About the application

Application number: 2026/90965	
What is the application for?:	Erection of detached outbuilding to create dwelling forming annex accommodation
Address of the site or building:	48, Meltham Road, Honley, Holmfirth, HD9 6HL
Postcode:	HD9 6HL

Drawing Title: **EXISTING & PROPOSED
SITE LAYOUTS**

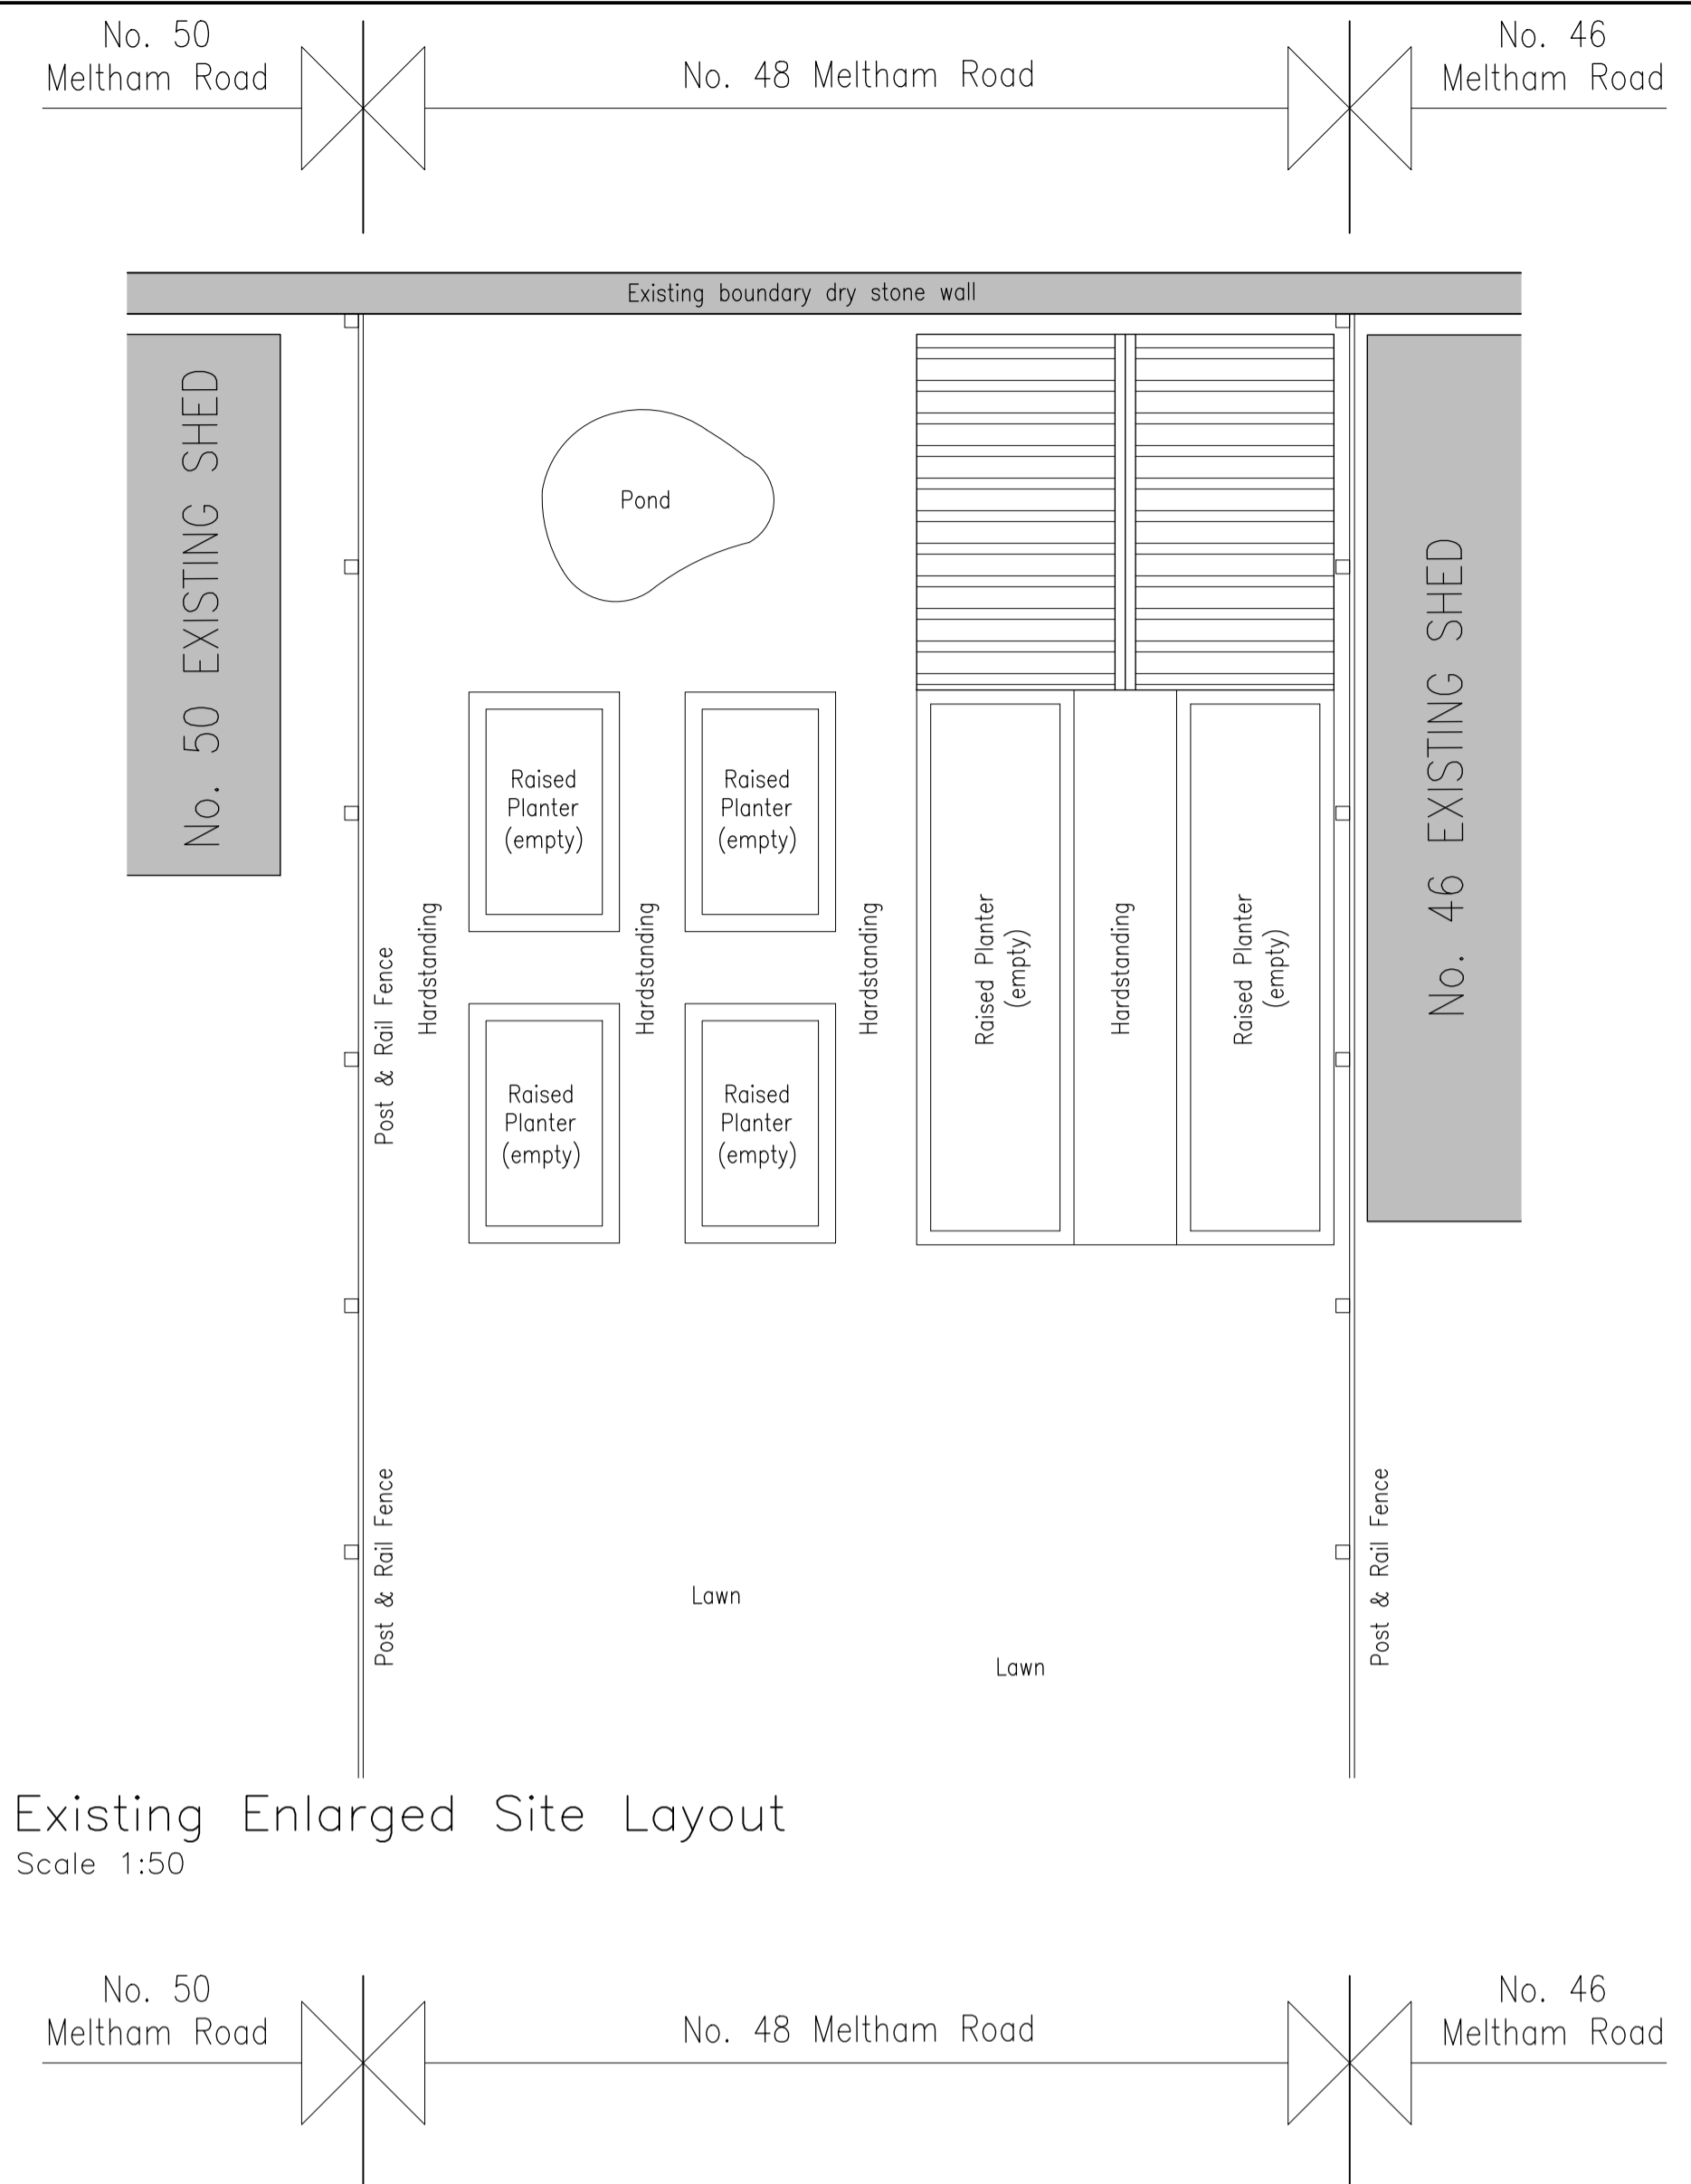
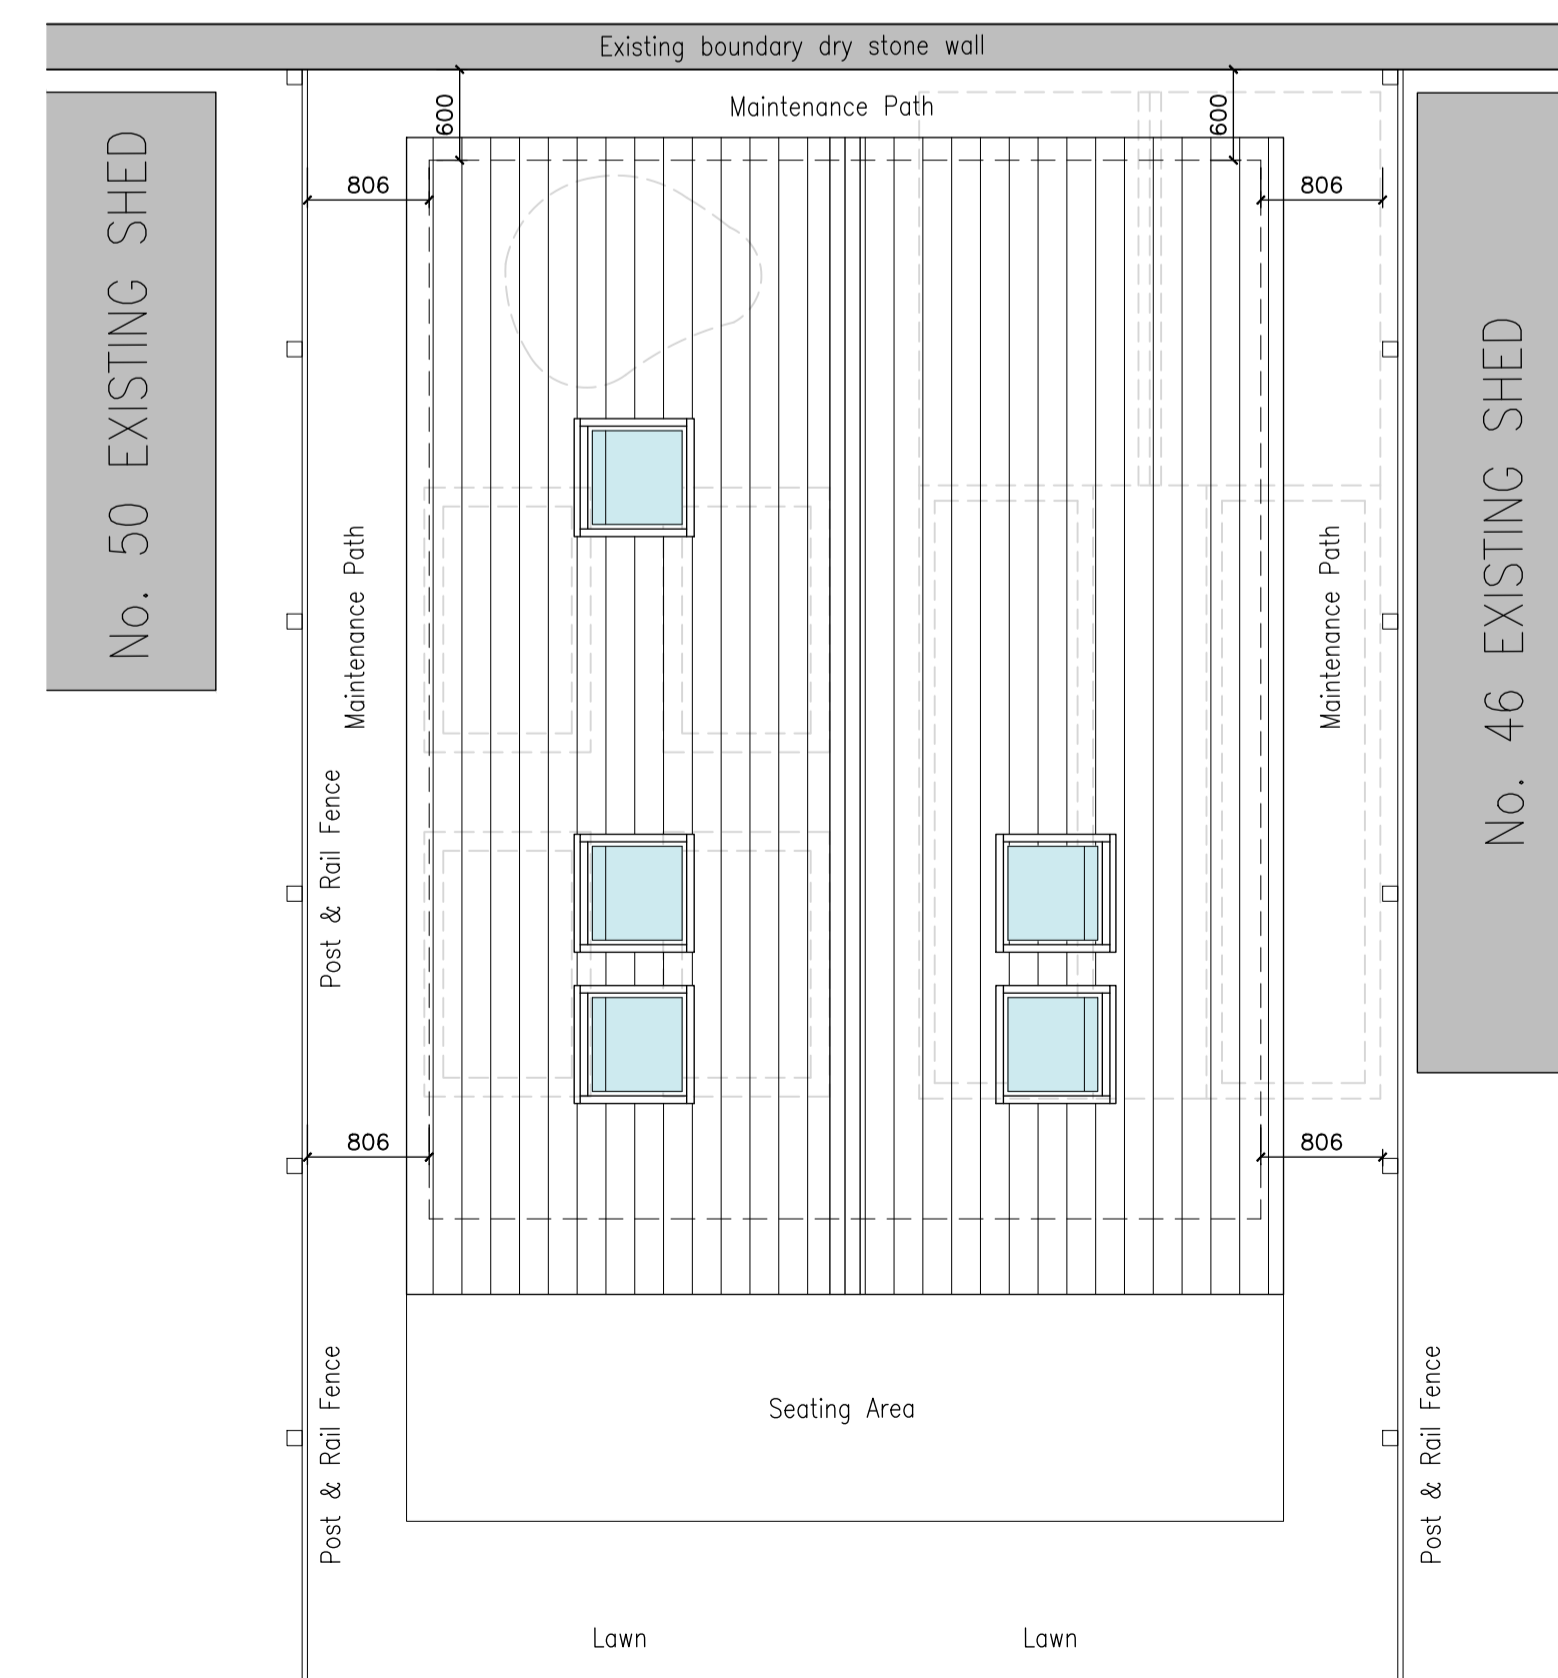
Type of comment: A general comment	
Do you wish your comments to be published on the website anonymously?	<input type="checkbox"/> Yes
<p>As per the comment . The plans are incorrect as there is now an approved house at 3a Croft Drive which backs directly on to this planning . Parking states 3 cars (it is currently full with 2 so unless it's a tiny toy car you won't fit a 3rd car in the front area) Kirklees council are currently putting double yellow lines around the whole area of this build so where will this tiny car go . How will they actually transport any building equipment up a 1m path to this request . Will assume sewage will join the mains ? And what actually is this annex for ? It's closer to Croft drive than the house requesting . So impact to noise and location to neighbouring houses needs to be considered.</p>
